From: Zhaleh Najari alamouti <Zhaleh.ALAMOUTI@transport.nsw.gov.au>
Sent: Tuesday, 17 March 2020 12:27 PM
To: Patrick Copas
Cc: Olivia Hirst; Pahee Rathan
Subject: RE: Major Projects – New Request for Advice - MOD 1 - Diesel fuel storage and generator arrangements (SSD-9741-Mod-1) (Lane Cove)

TfNSW has reviewed the proposed modifications to approved Data Centre - SSD 9741 and requests the following information for further assessment:

Section 1.1 of the Modification Application Report states that the zone in the eastern end will be utilised for an additional data hall which will require the lowest level to be set at RL8.4 instead of RL9.9:

Drawing Number
ATSYD2_SSD_DRG_ARC_0100

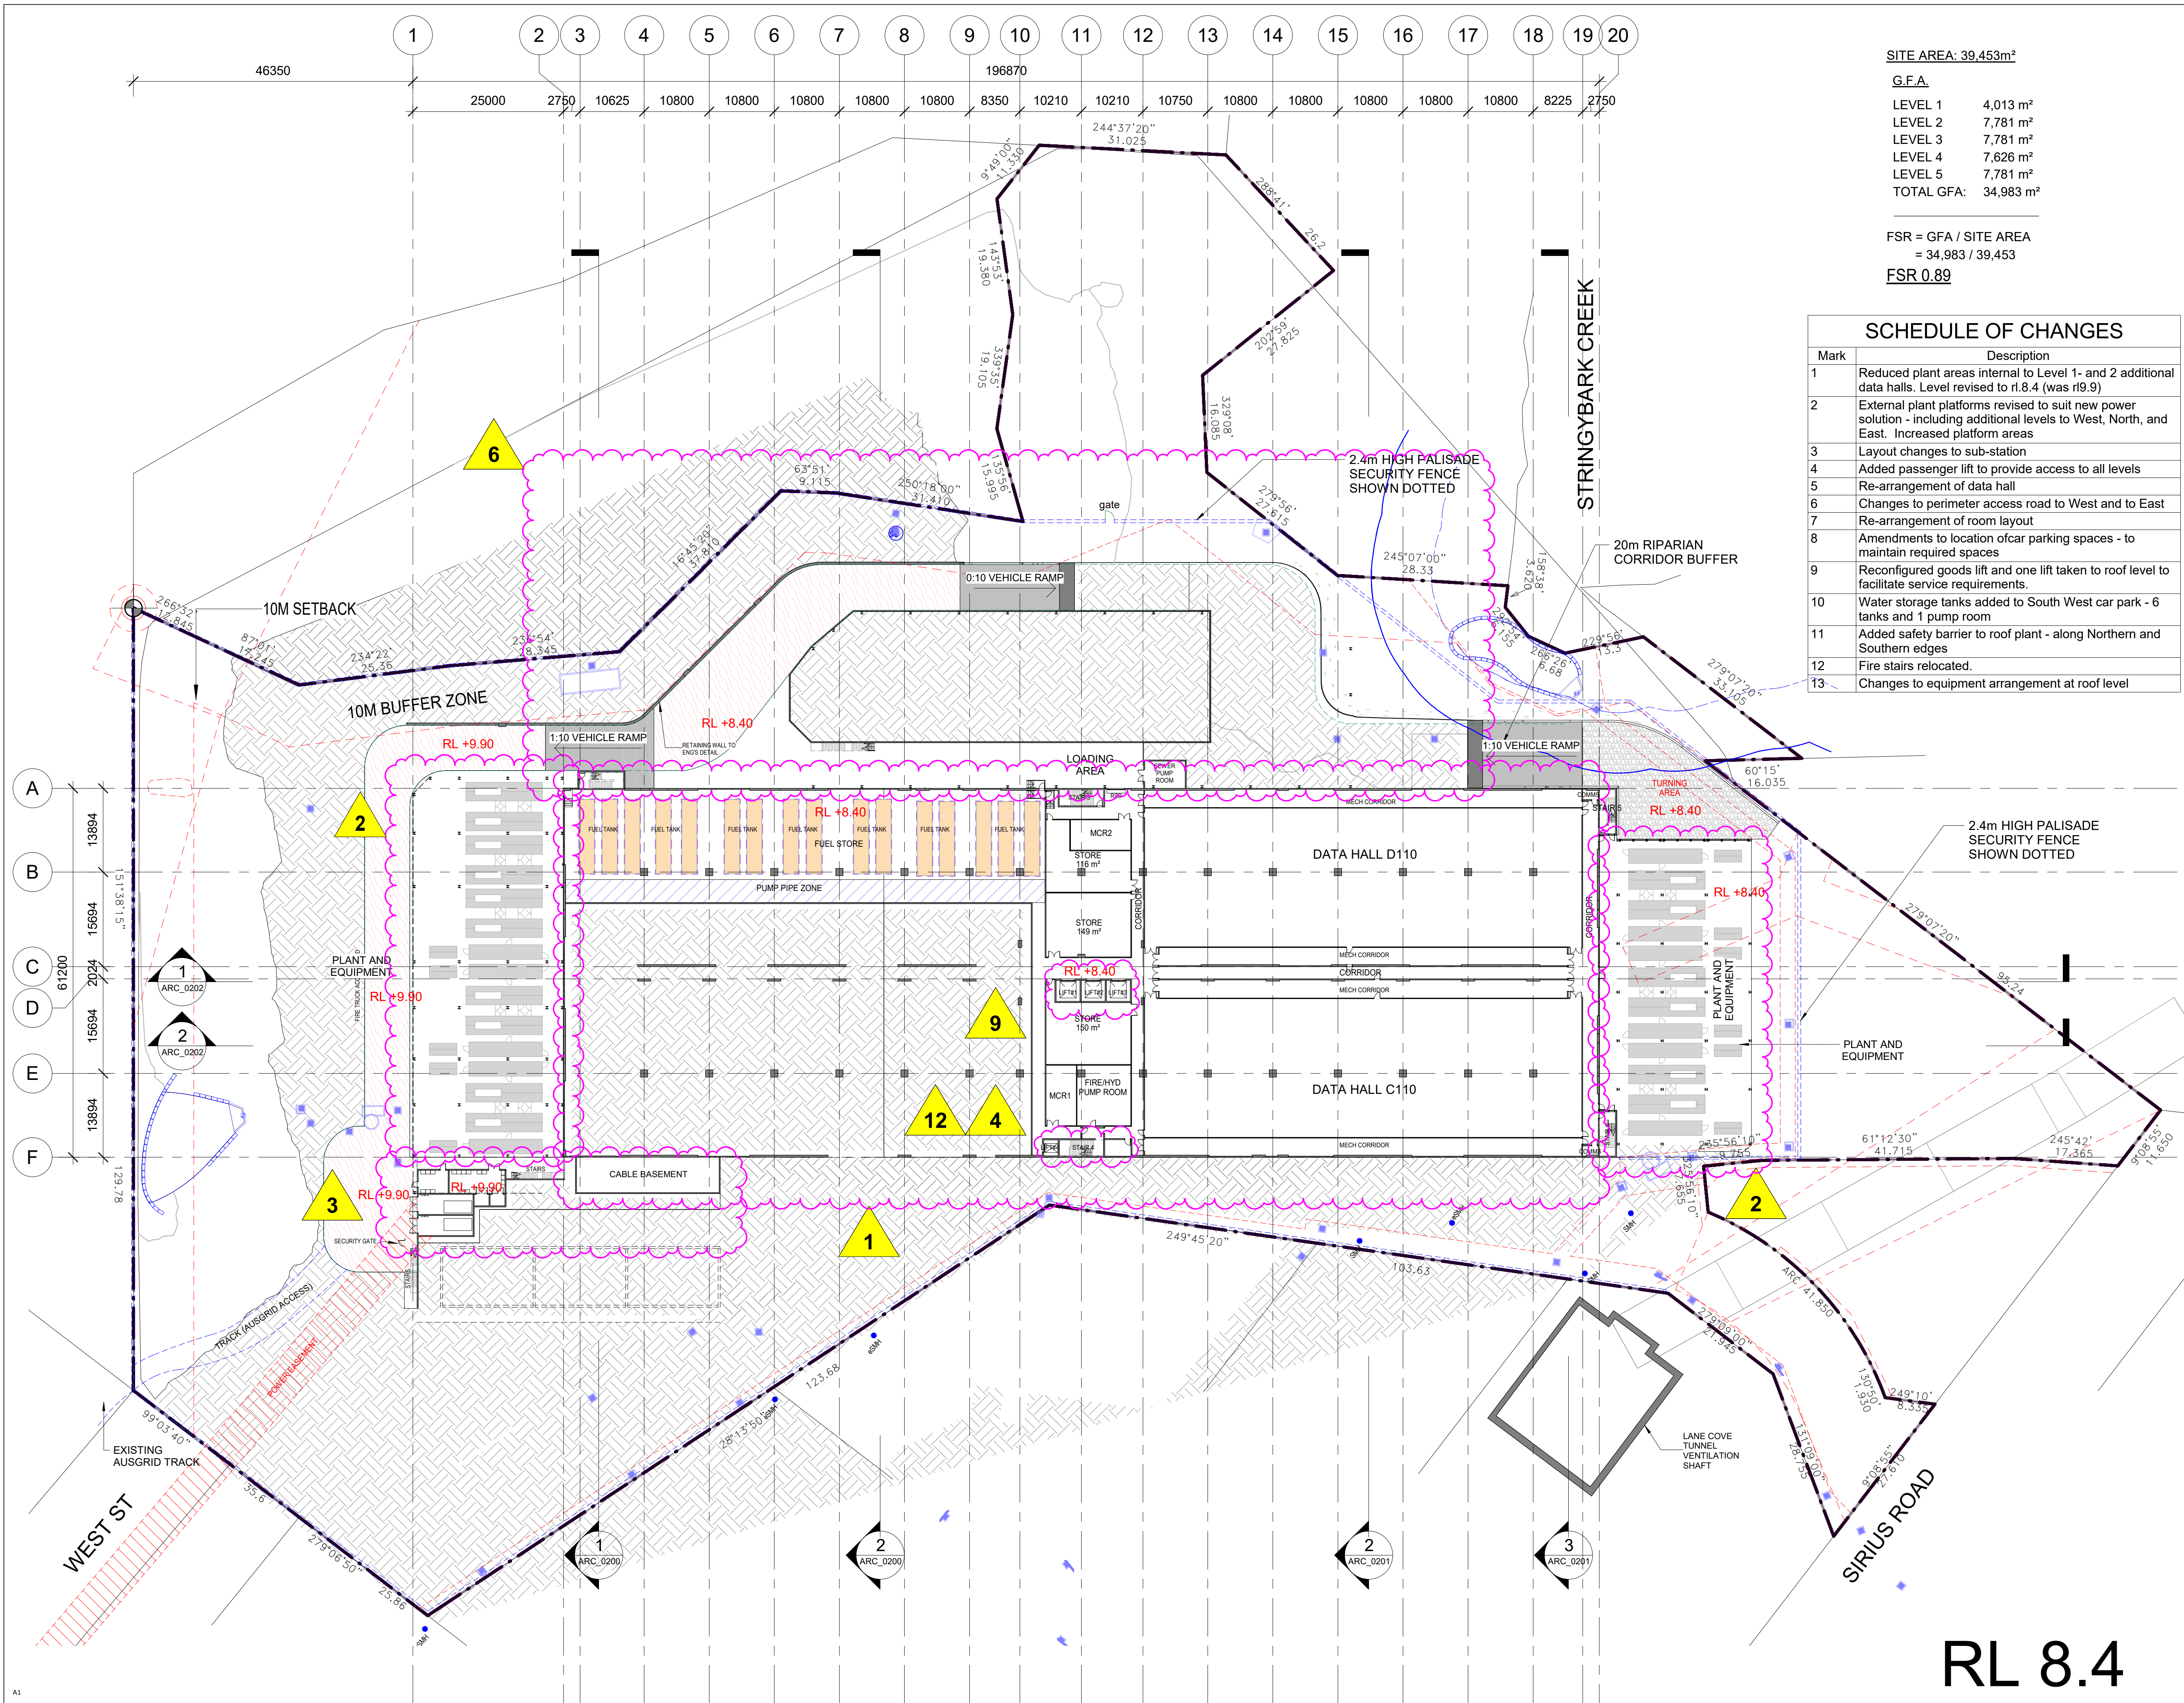
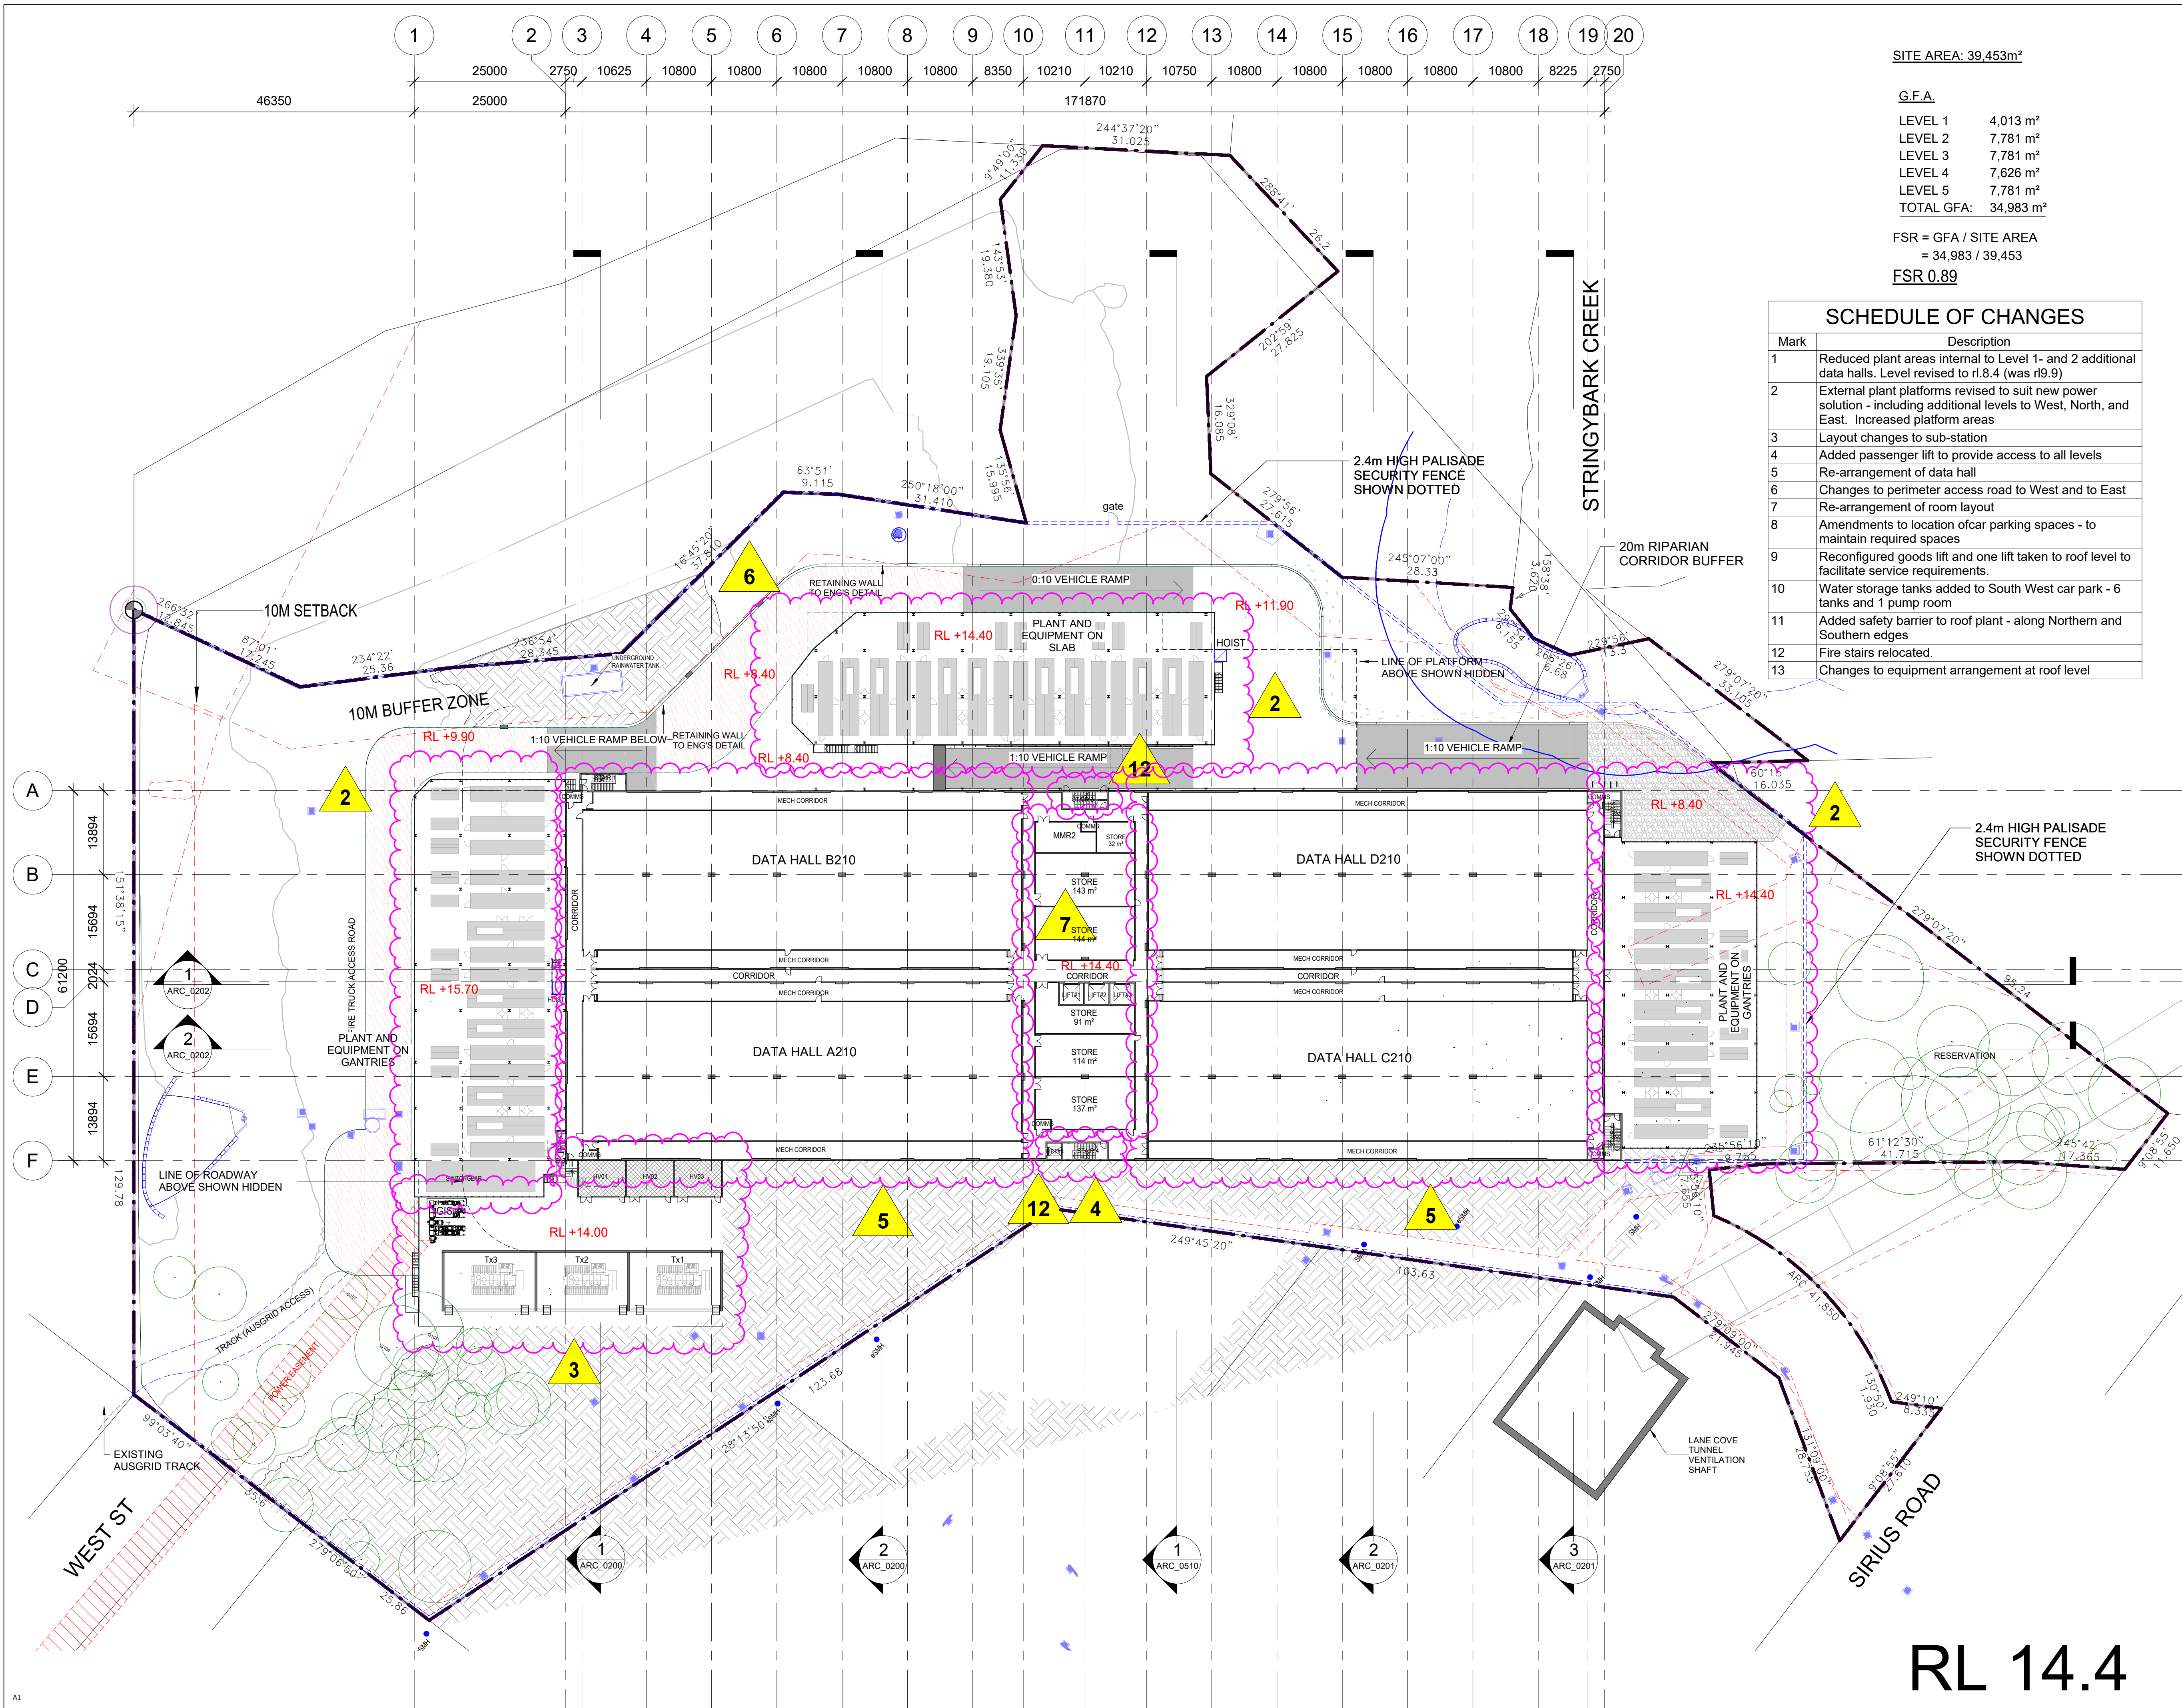
- Will there be changes to the RL of the piles?
- Will the change impact on the LCT Ventilation Exhaust Tunnel?
- Please provide updated drawings which show the RL of the piles and distance of the piles relative to the Ventilation Exhaust Tunnel.
